Engineers Comments Regarding Surface Water Drainage

Application Reference:	WA/102/24/PL	Reviewer Reference:	ADC/SB
Planning Officer:	Amber Willard	Date of Review:	31/01/2025
Site Name:	Longacre The Street Walberton BN18 0PY		
Application Description:	Erection of 6 No. dwellings with car ports and car parking along with a new ecology and open space area with use of existing access onto The Street. This application is a Departure from the Development Plan, may affect the setting of listed buildings, may affect the character and appearance of the Walberton Green conservation area, is in CIL Zones 2 and 3 and is CIL liable for new dwellings.		
Assessment Number:	1 of 1

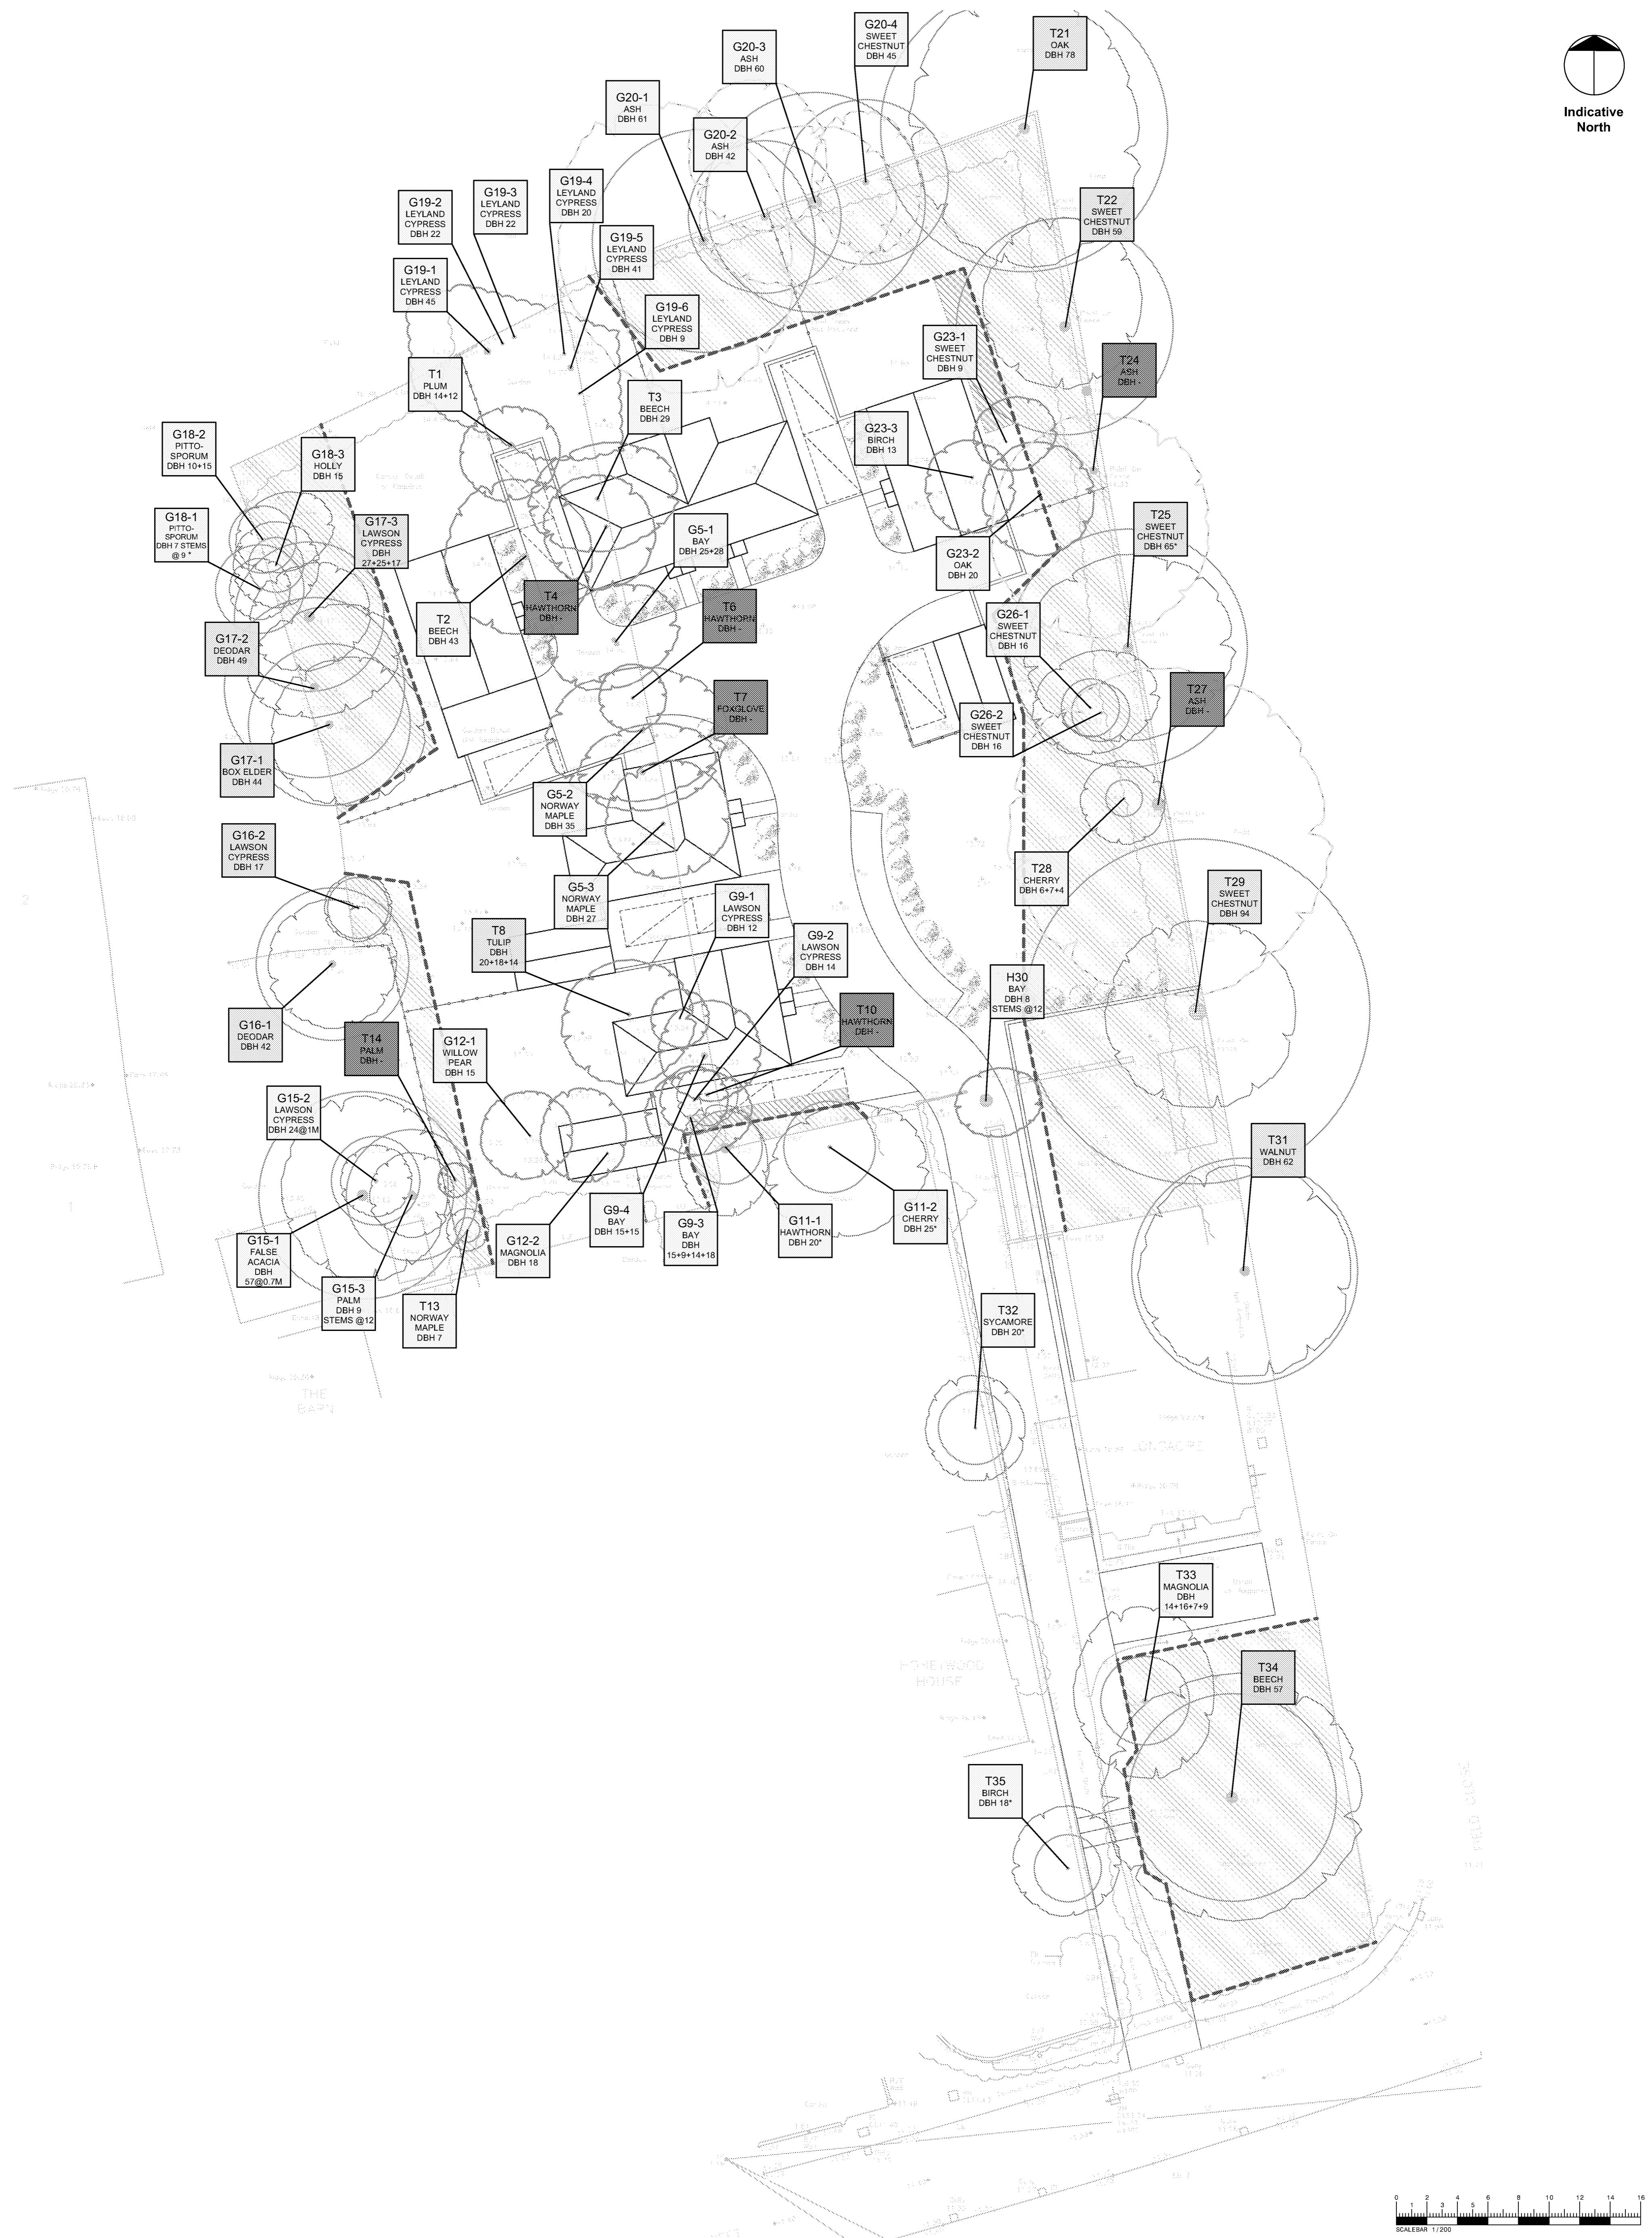
The site has several trees of varying significance and additional planting proposed as part of the development. Please consult the tree officer to ensure that the proposed use of permeable paving will be acceptable in the vicinity of existing trees. It may be necessary to adjust the levels of the paving and storage in tree root areas and the design needs to account for this in advance of determination.

Careful consideration will also need to be given to the detailed surface water drainage design to ensure that tree roots do not damage the impermeable liners of the permeable paving or any other components. If the liners are damaged and allow groundwater ingress, then this will increase flood risk as the storage required to drain the development could be consumed by an unquantifiable amount of groundwater.

1. Evidence of the existing drainage arrangements for Longacre – with the drainage design adjusted as necessary.
2. All watercourses and their easements clearly marked on the layout with no obstructions within those easements.
3. Permission in principle to connect surface water to the culverted ordinary watercourse on The Street. This should include recognition and commitment to any remediation works that are necessary. (Surveys may be required).
4. Evidence that the surface water drainage proposals do not conflict with the existing trees and their root protection areas.
5. Evidence that interception drainage is provided for all positively drained areas.

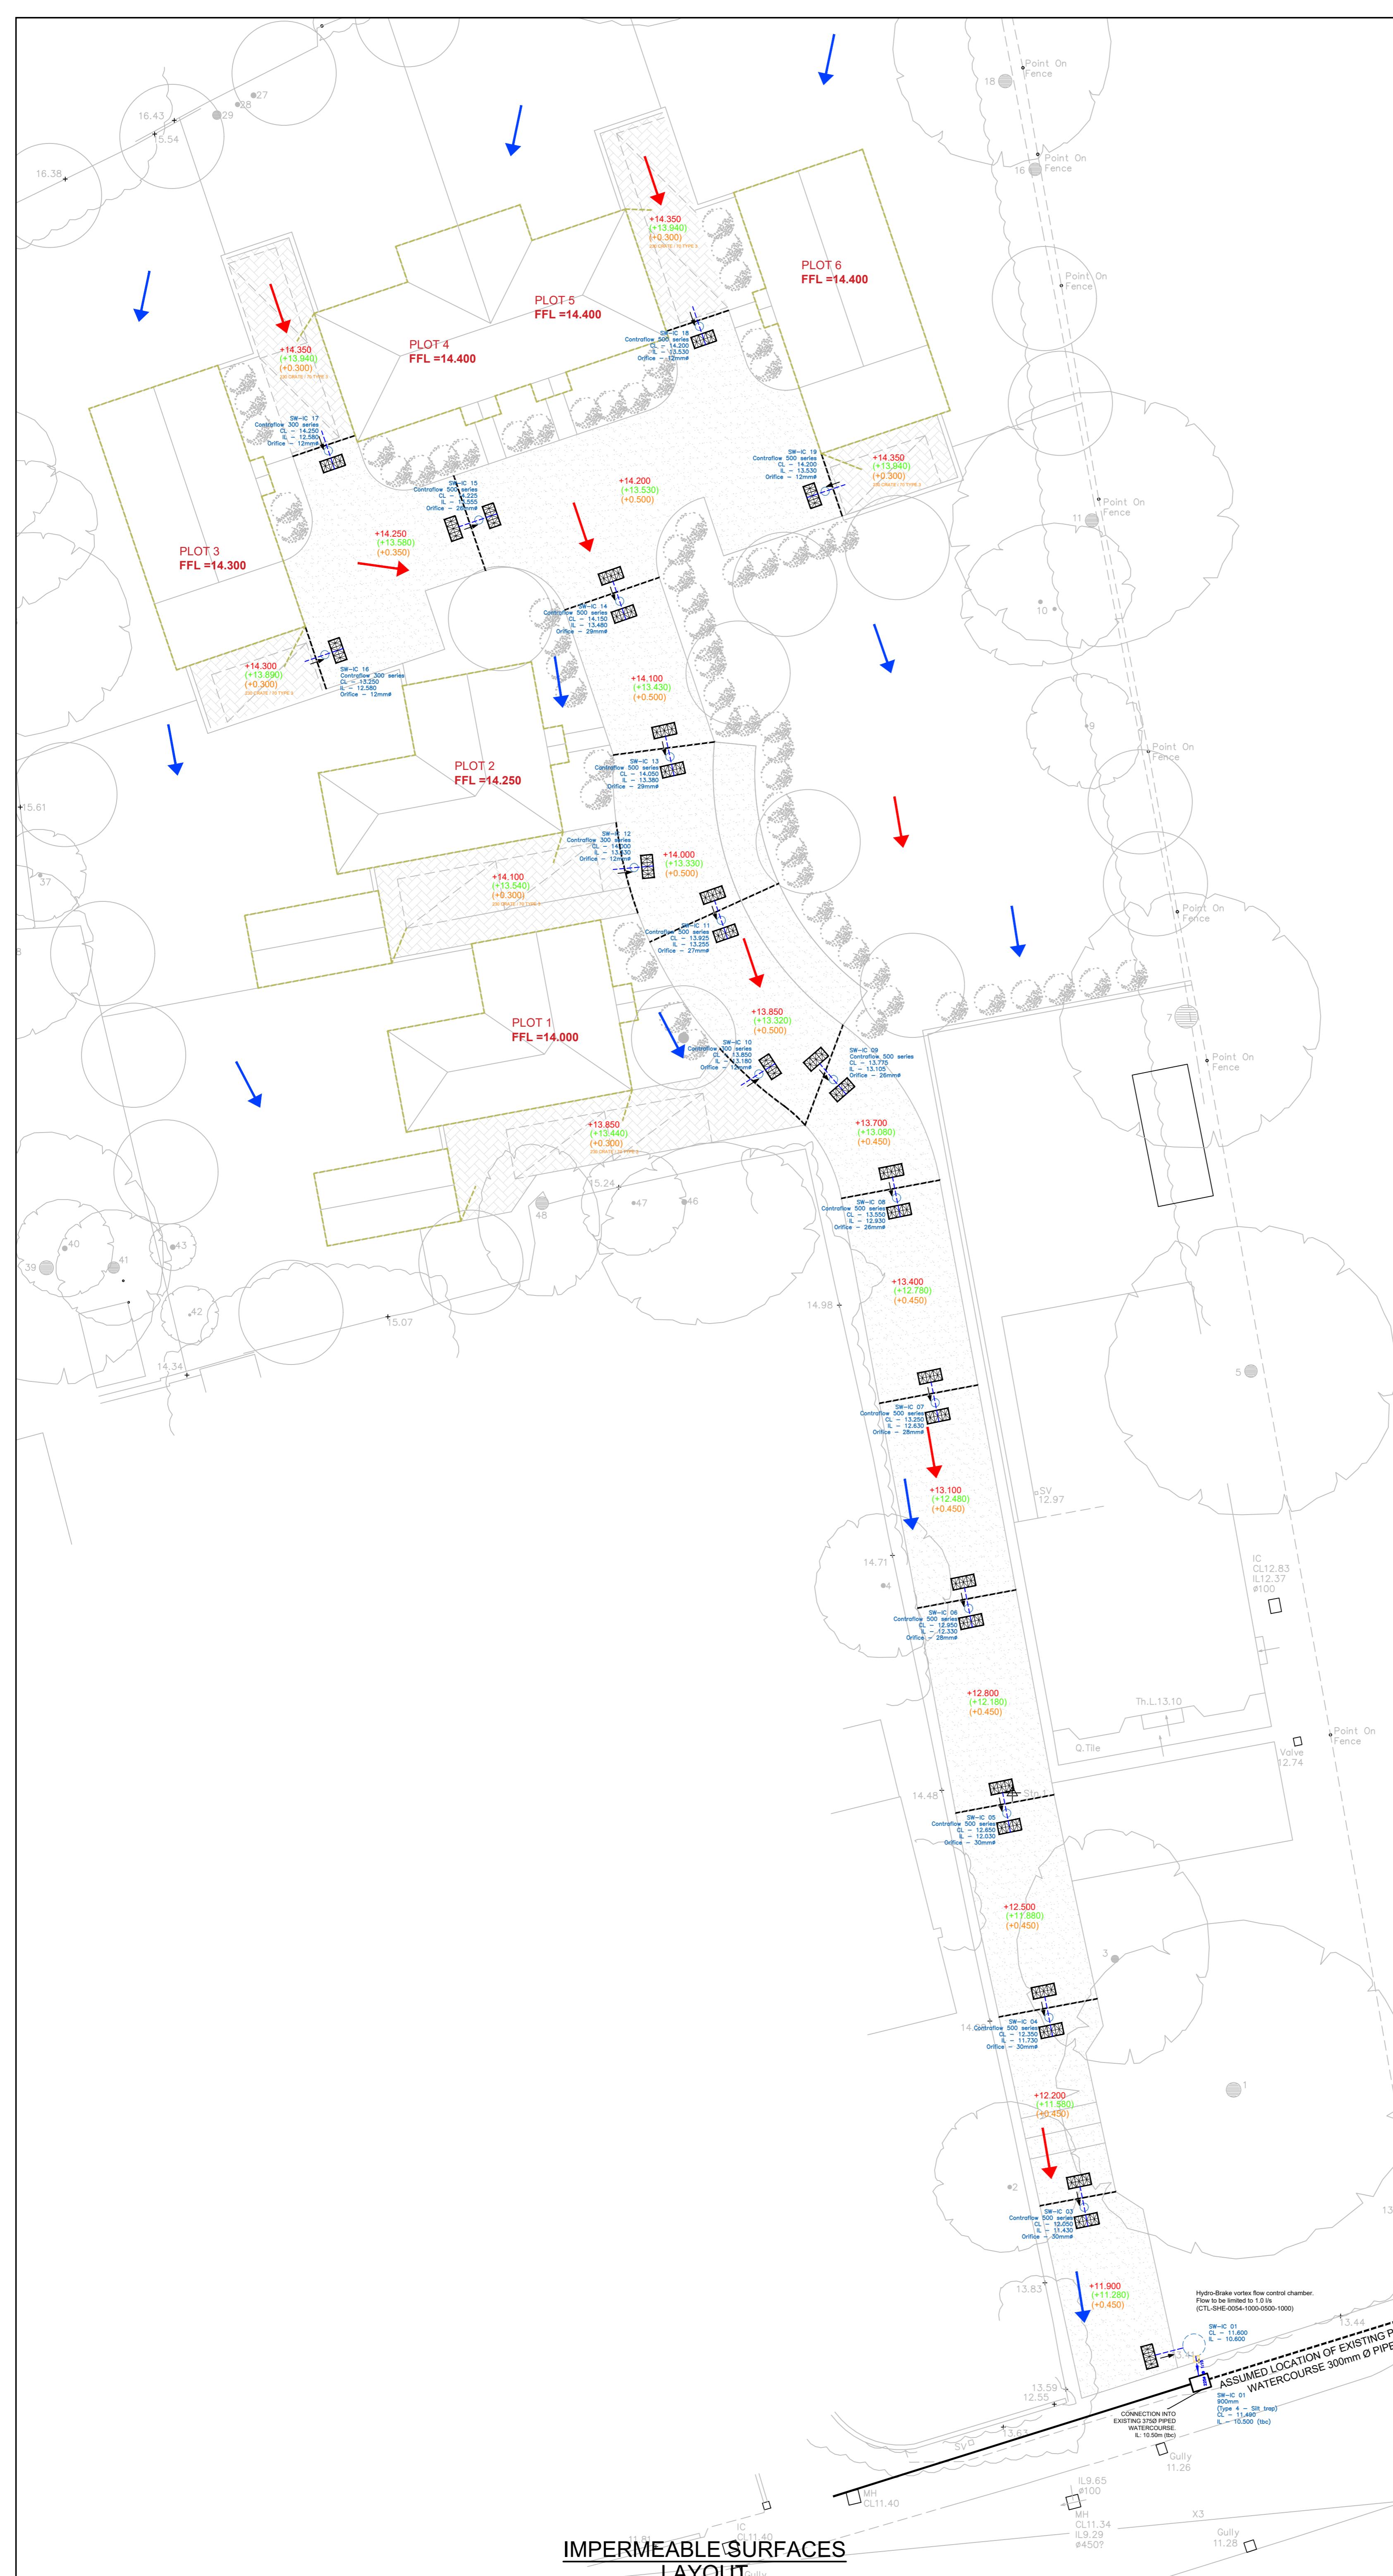
The drainage strategy is entirely dependent upon the proposed connection to the culverted watercourse, yet the drainage strategy makes no mention of the status, condition or permissions that are required to make the connection. It is anticipated that ordinary watercourse land drainage consent will be required. With the knowledge that piped networks already flood on The Street, it is likely that remediation works will be required to ensure that the culvert can receive the proposed flow. There is no evidence of permission in principle, condition surveys or agreement to remediation works. This is critical as if permission is not given then there are no obvious alternative ways of draining surface water from the site. Sustainable means of draining the site are summarised as follows:

In addition to the culverted watercourse on the southern boundary, our records also indicate that there is an open watercourse on the northern boundary. Our land drainage byelaws stipulate that there must be no obstruction within 3m easement from the top of the bank of an open watercourse. Defined obstructions include buildings, structures (temporary or permanent), plants, trees and shrubs. It is unclear from the plans that have been submitted whether this byelaw is adhered to by the proposed development. However, fencing is shown extending to the extreme northern boundary.

Interception drainage has not been adequately considered by the submission. This is an important consideration as when the drainage system is designed in accordance with The SuDS Manual, runoff for the majority of small (frequent) events will be prevented from leaving the site. This is the first water quantity standard prescribed by the manual. Designing for interception is more challenging where infiltration is not viable as it must be provided via evapotranspiration only. The lined permeable paving is assumed to provide interception for the rain that falls on its surface but not for the additional impermeable areas of the roofs that drain to it. The designer has limited options to provide this interception drainage and all of them involve some form of open feature that will allow evapotranspiration to occur. These can include green roofs, lined swales (designed for this purpose) rainwater gardens and bioretention areas. It is important to recognise that all these features can also contribute to the biodiversity and amenity benefit of the drainage scheme. The inclusion of open features to meet the interception criteria may impact the layout and scale of development.

There are several discrepancies between the calculations and the drainage layout. These generally relate to the depth of storage in relation to the proposed invert levels. This must be corrected as part of the detailed design however the discrepancies are not considered to be significant enough to potentially affect the scale, layout or landscaping of the proposed development.
